HTE# BUS 2209-0018

EXISTING SEPTIC SYSTEM INSPECTION

PURPOSE OF INSPECTION: 15' x 30' in ground Pool

BLOOM POOL PROJECT
338 WINDY FARM DR,
FUQUAY VARINA, NC 27526

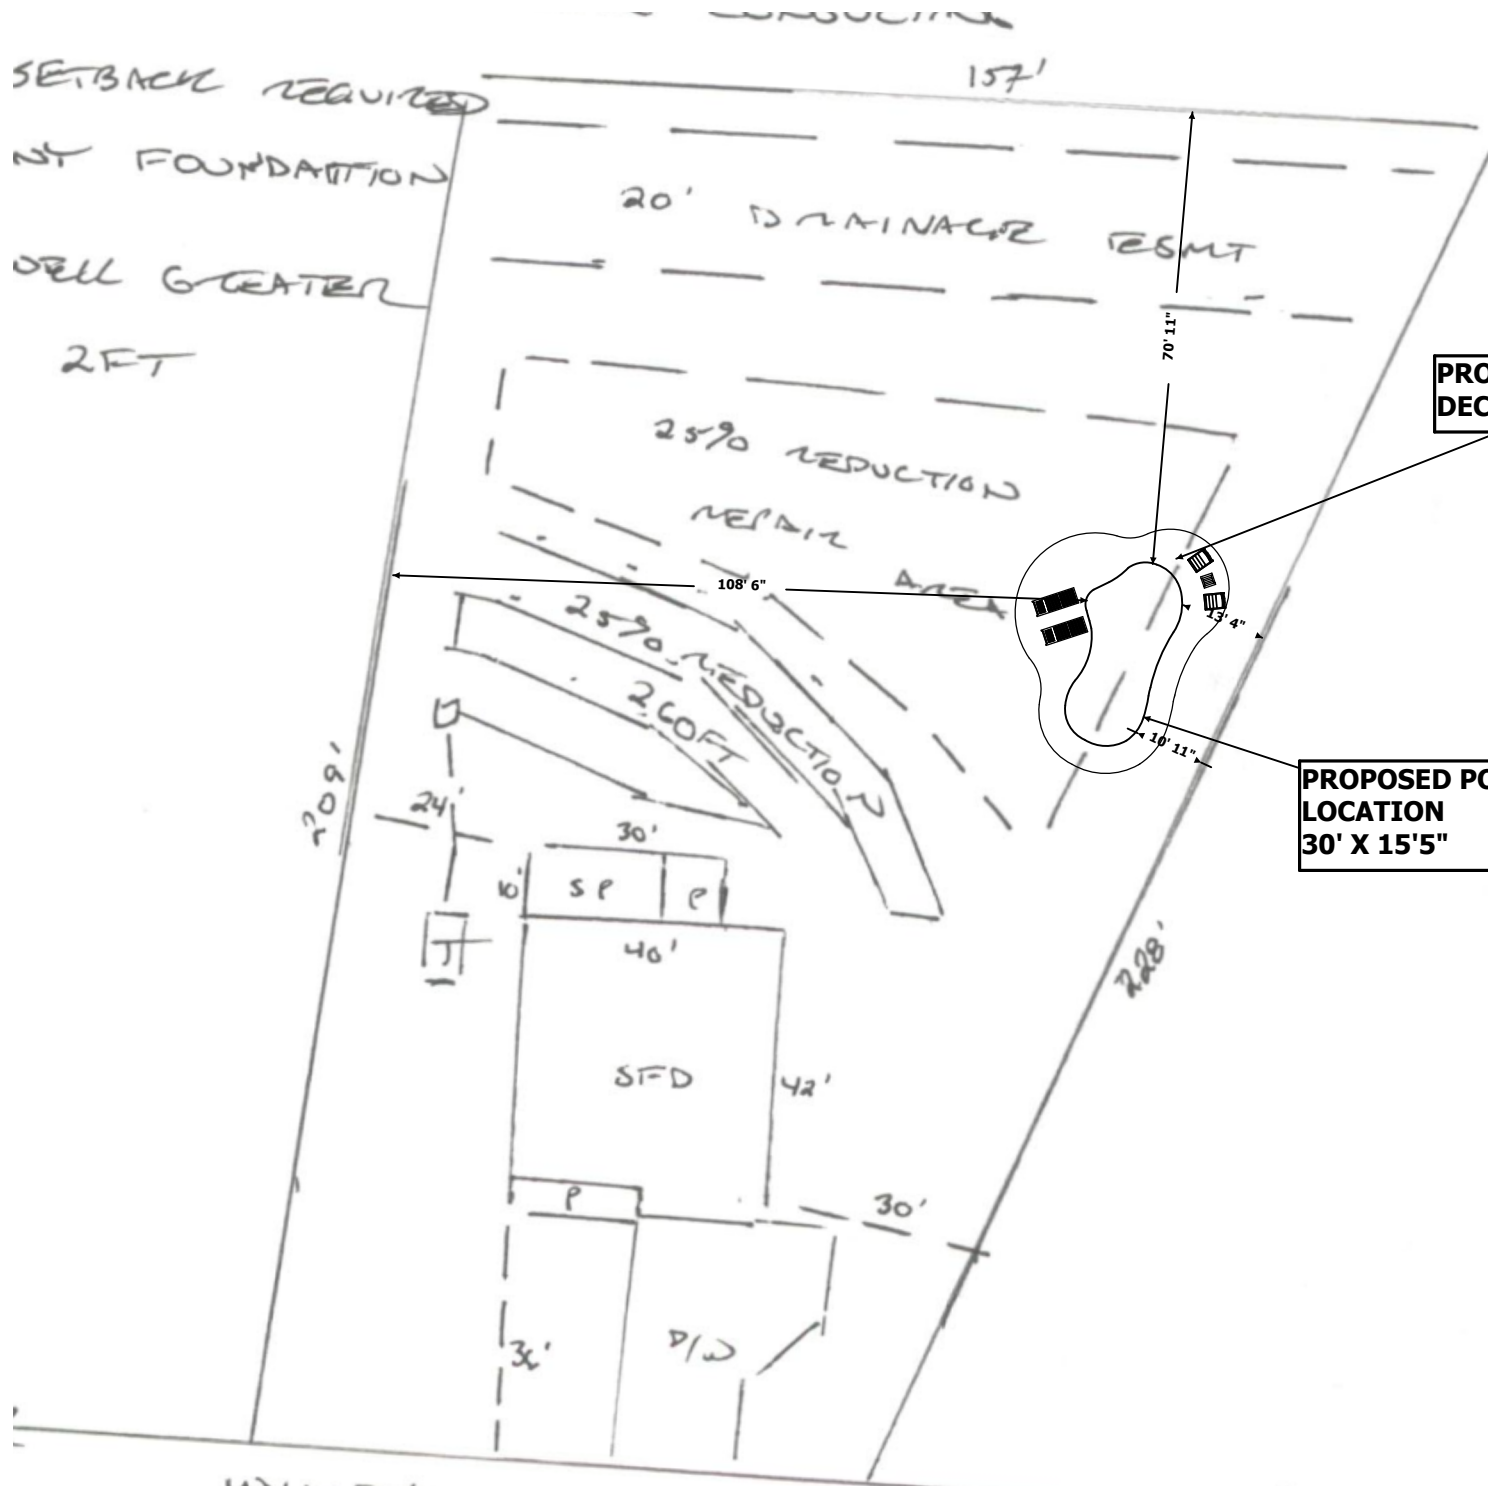
*Repair changed
to
50% RSD*

**BUILDING MUST BE 5' FROM ANY PART OF SEPTIC SYSTEM
DO NOT DRIVE OR PARK ON SEPTIC SYSTEM**
